Memorandum ABP-314501 – Request for Further Information

Re: South Dublin Street and Backlands Regeneration Project. The proposed

Date: 10th February 2023

**CDG-
DR-A-20-001
- Existing and
Proposed
Dublin Street
Elevations (A2)**

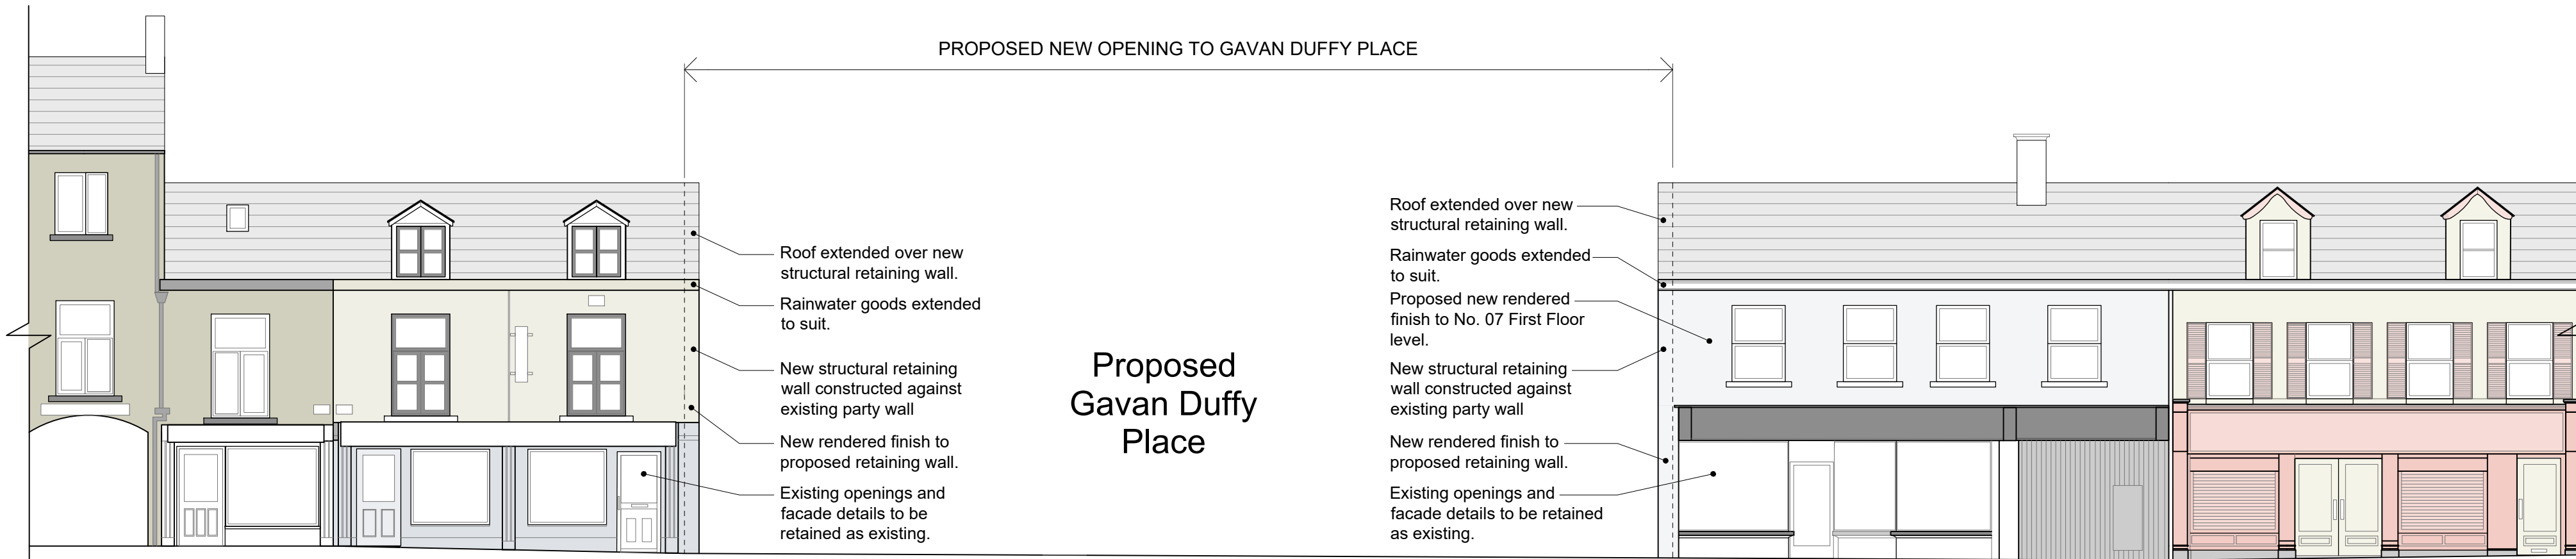
The aforementioned recent national policies, the concerns that the proposal is a "modern car-focused proposal", the proposed demolition of part of the streetscape opposite a group of structures within the Dublin Street ACA, the cultural significance of one of the buildings to be demolished and the lack of justification for the vehicular connection to Dublin Street, when taken in totality, suggest that an alternative proposal for enhanced pedestrian access *only* may be warranted.

The applicant is therefore invited to reconsider the proposed scheme and following consultation with the Department of Housing, Local Government and Heritage, submit a response to the concerns raised, including revised drawings as may be necessary.

- A detailed design statement, including details of design palette;
- Addressing the lack of active elevations for all sides of the new connection /
 Gavan Duffy Place, should it remain in some form;
- Complete elevations of blocks (to be amended/retained) along the new connection / Gavan Duffy Place.
- As a new square is also proposed to the east of Nos. 12 and 13 Dublin Street.
 Elevations, which includes the rear return of Peaky Blinders public house,
 addressing /enlivening this square are considered necessary.
- A reduction in the proposed block size or a mid-pedestrian link of the block between Church Walk and The Mall, Section 3.3.2 'Block sizes' of DMURS refers.

Project	MONAGHAN TOWN - DUBLIN STREET REGENERATION PROJECT			
Title	LONG SECTIONS THROUGH SITES PLAN			
File Identifier	Drawing No.	Status	Rev	
MGT0528-RPS-00-SS-DR-C-CS1014	CS1014	S3	P02

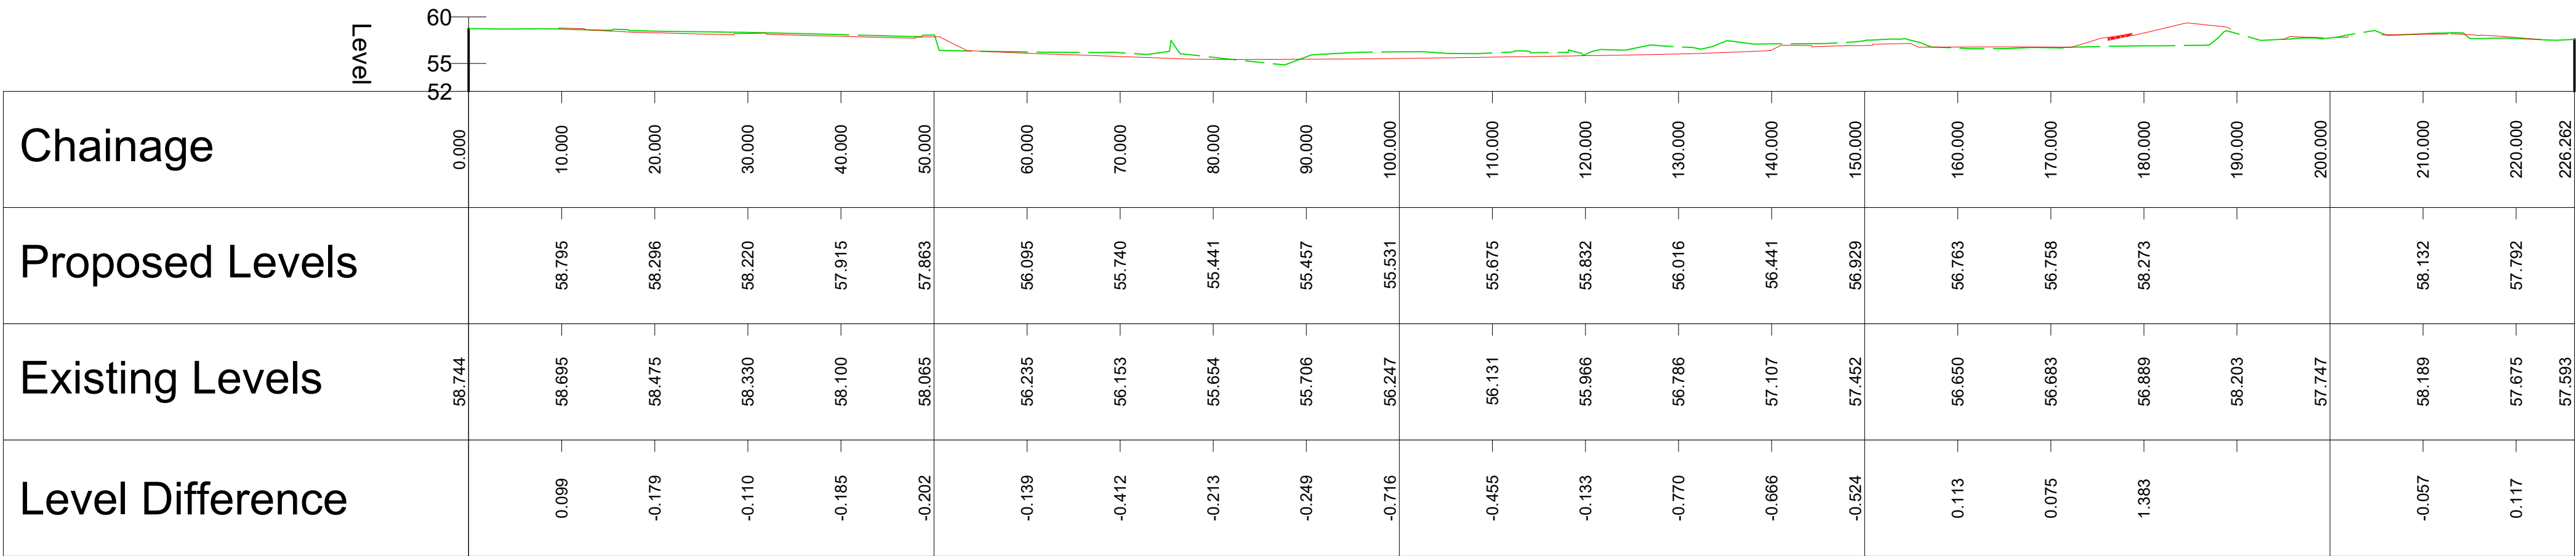
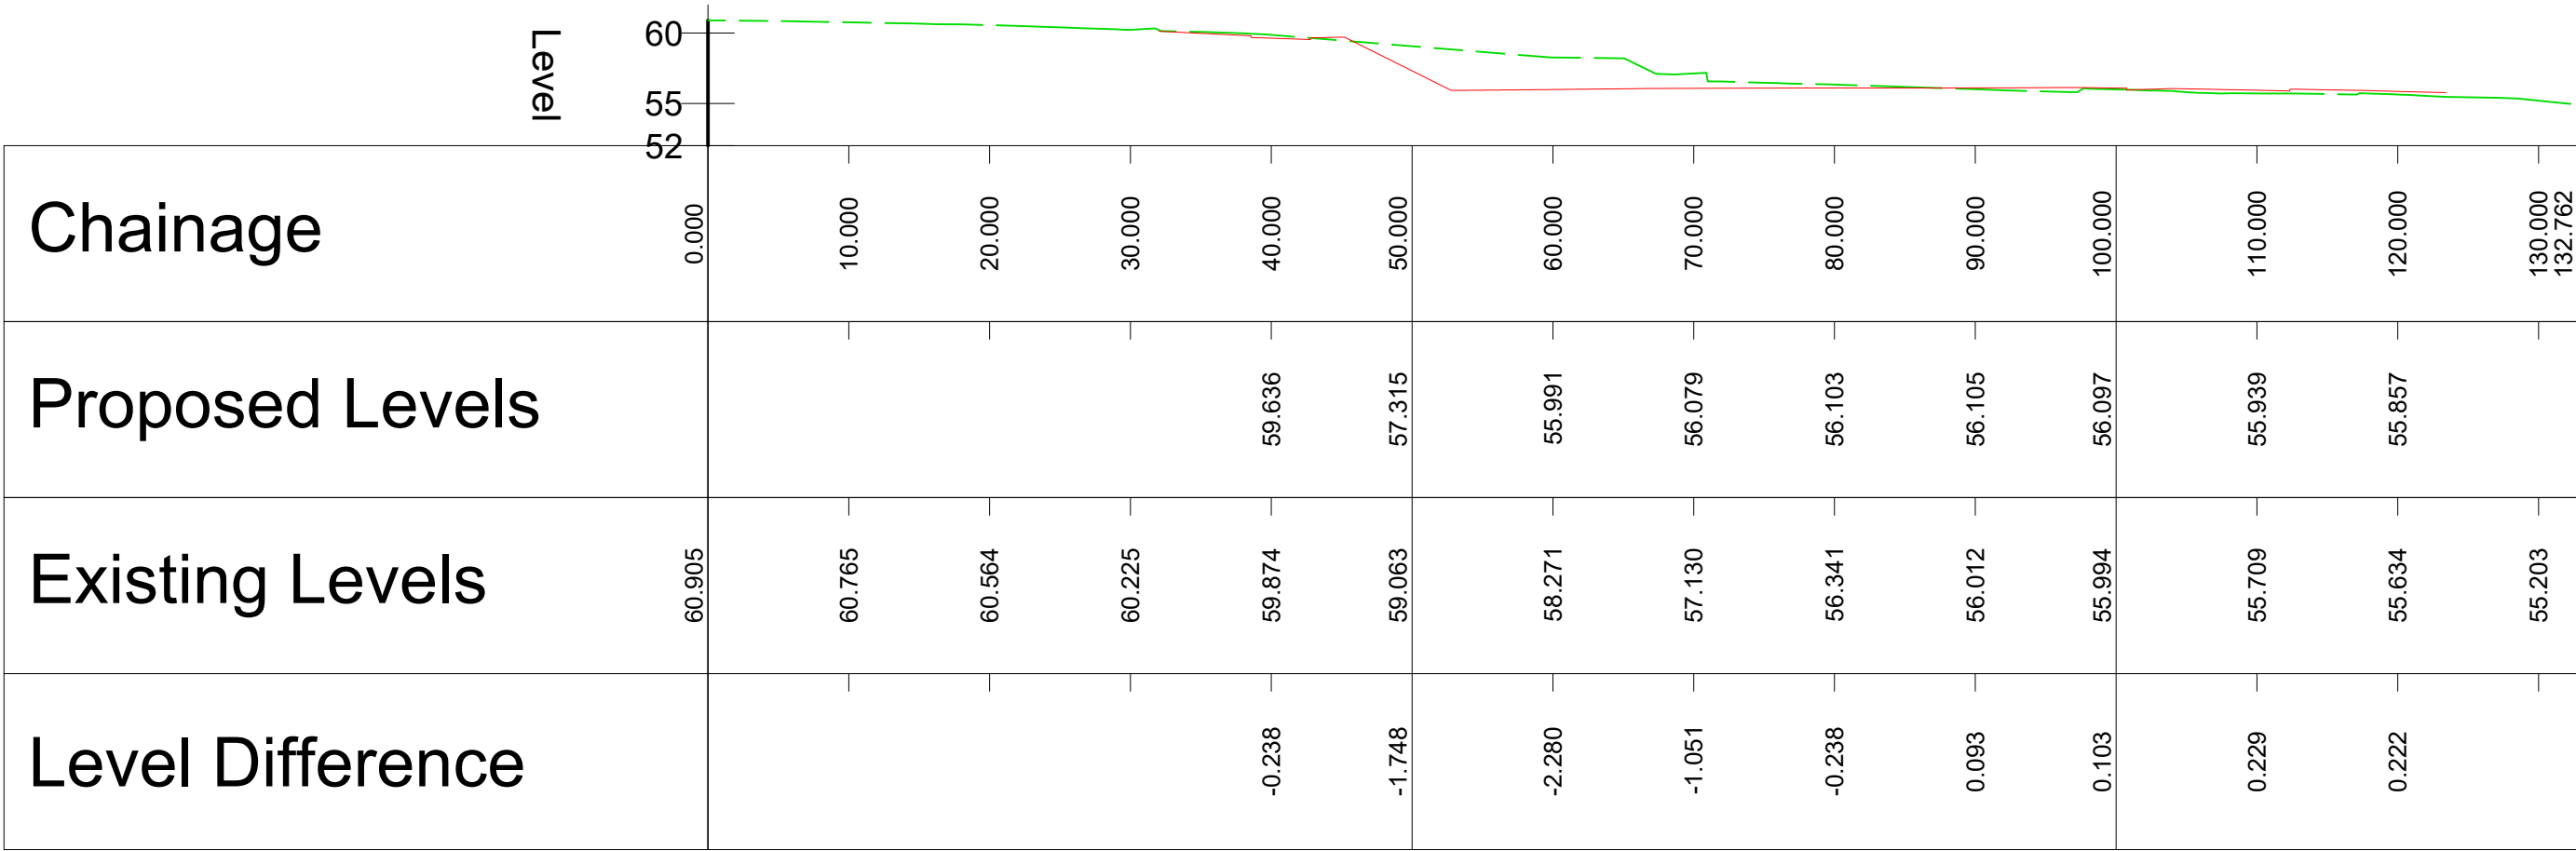
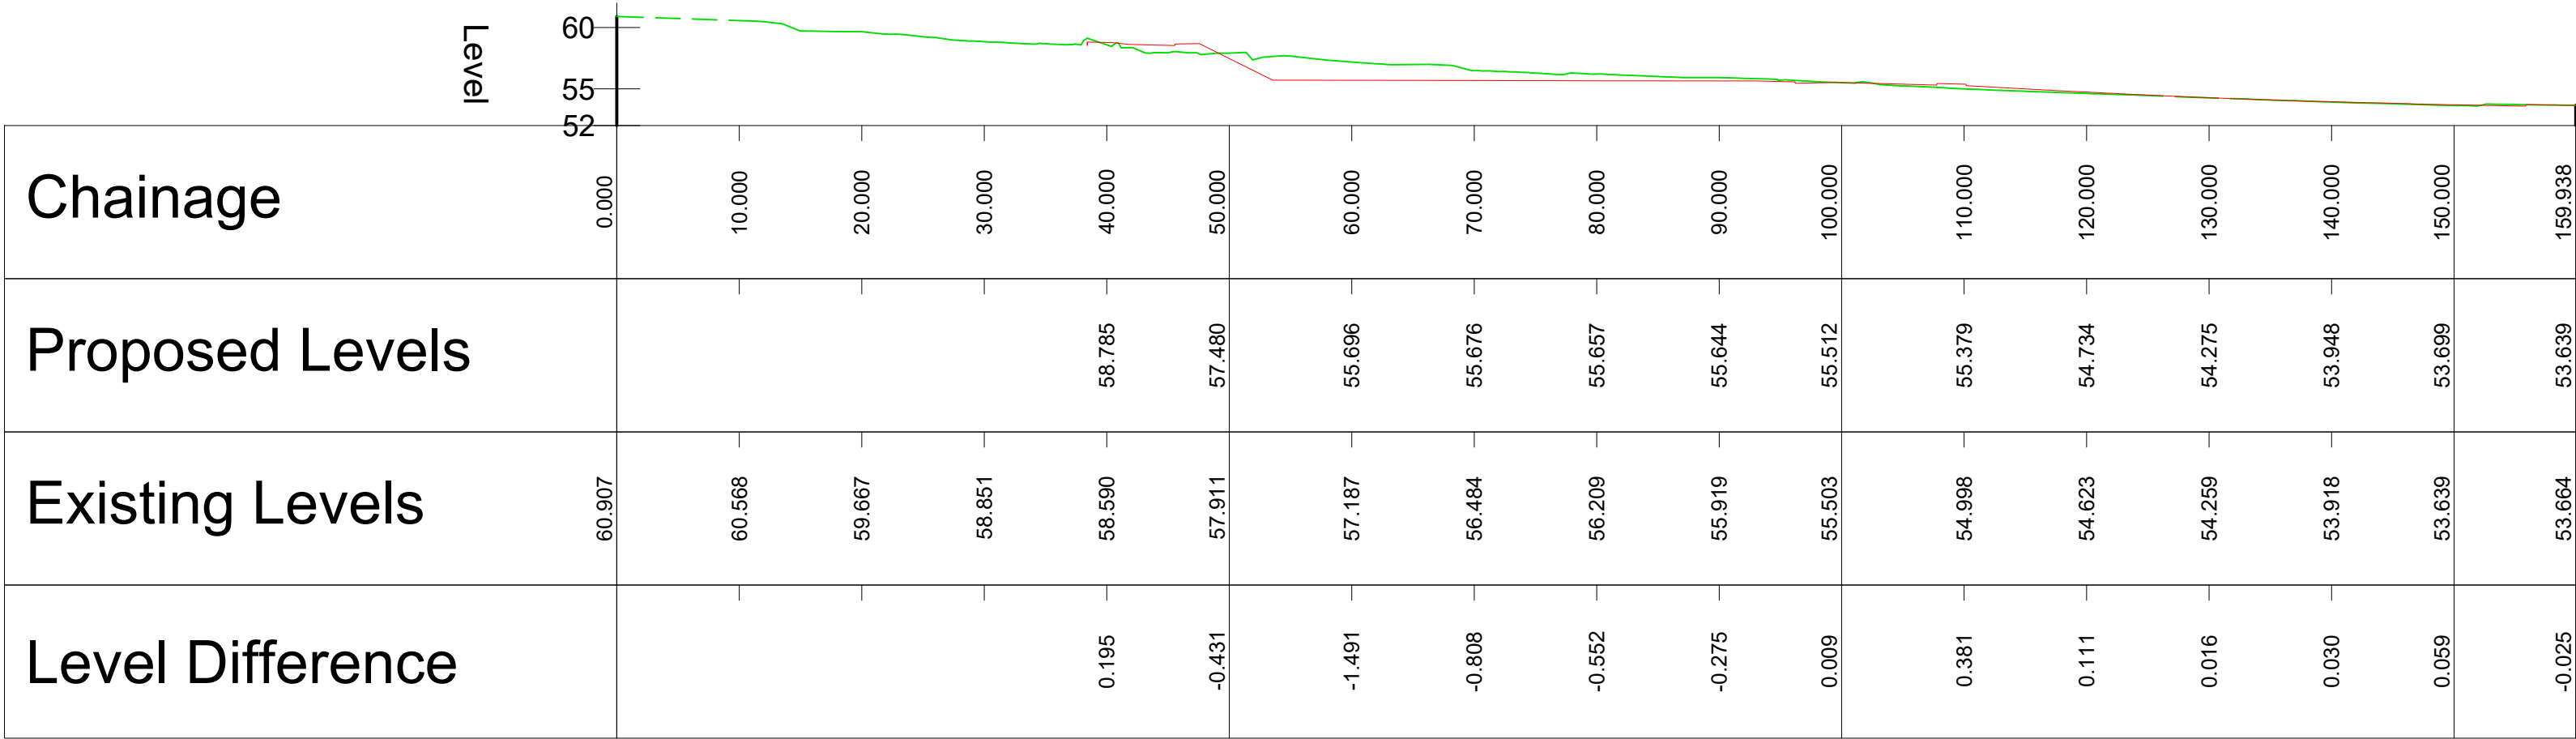
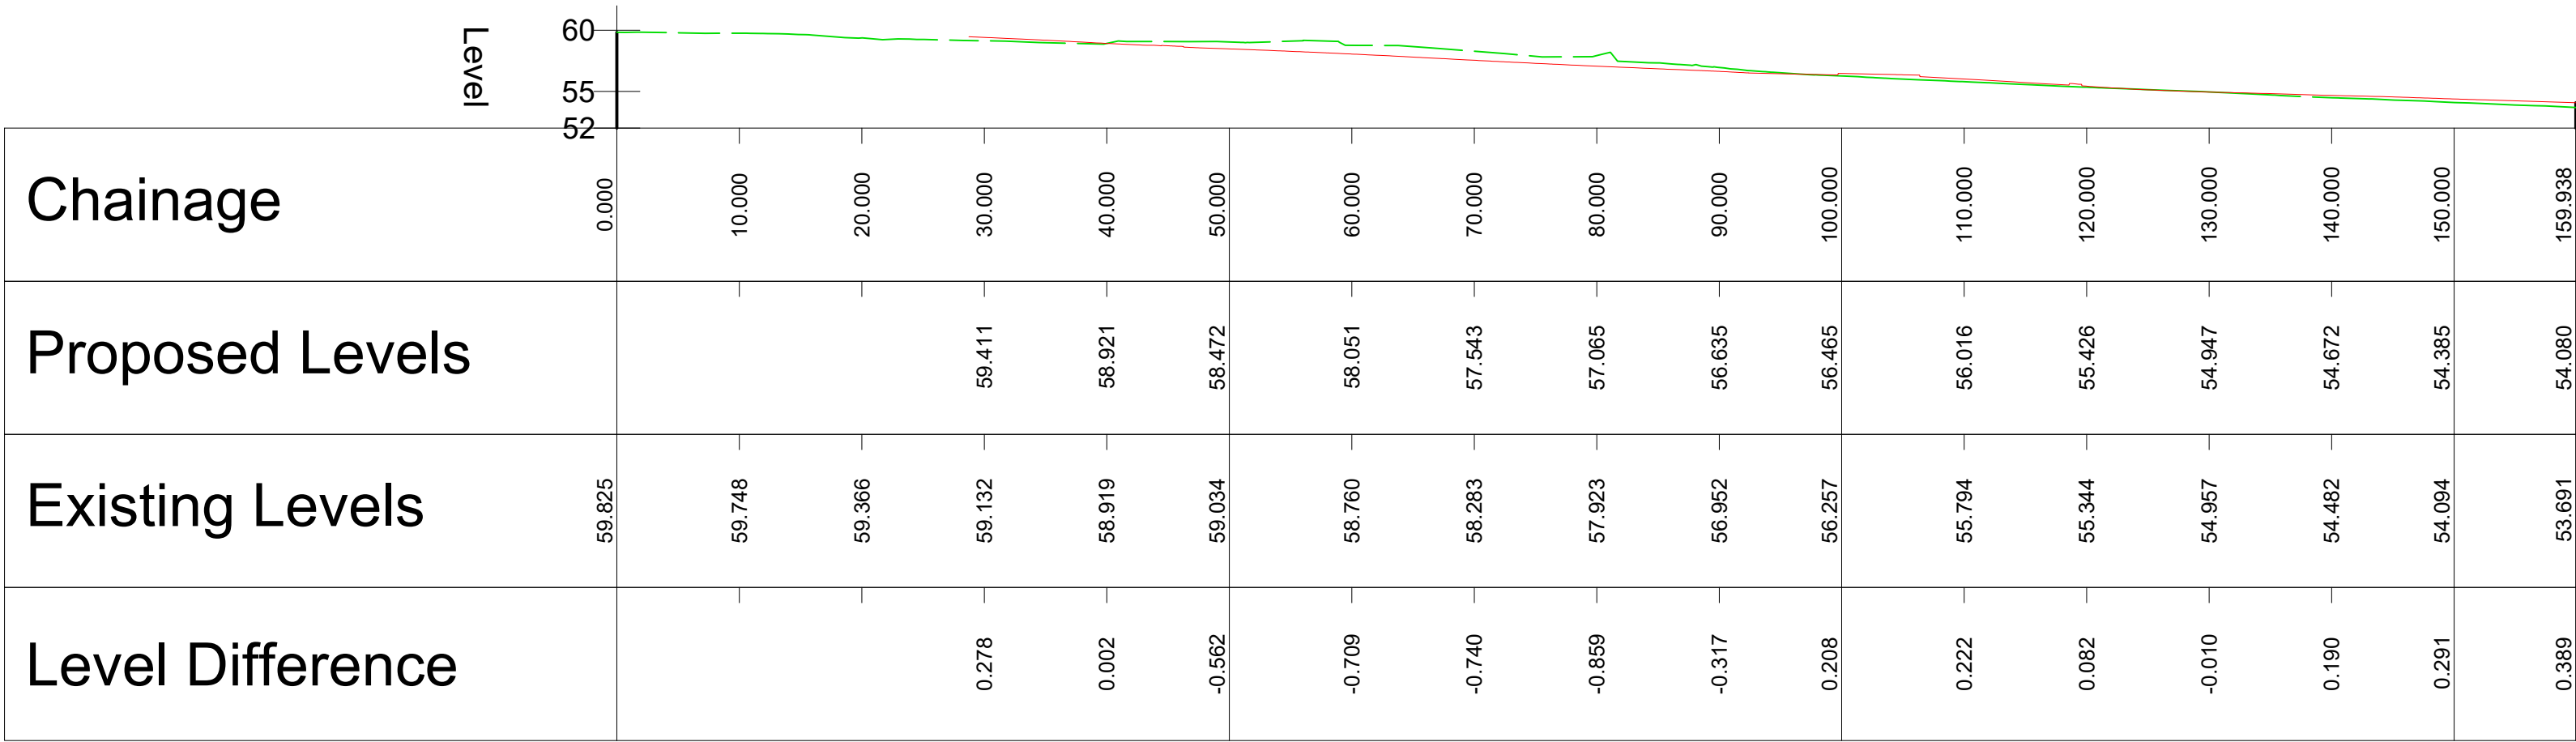
In the interests of clarity, please provide a comparison between the existing volume of attenuation and rate of discharge to the Shambles River and that proposed. Please also indicate how you have had regard to climate change in the flood risk assessment and infrastructure requirements. You are further requested to submit a cross section through the site and indicating the proposed attenuation area.
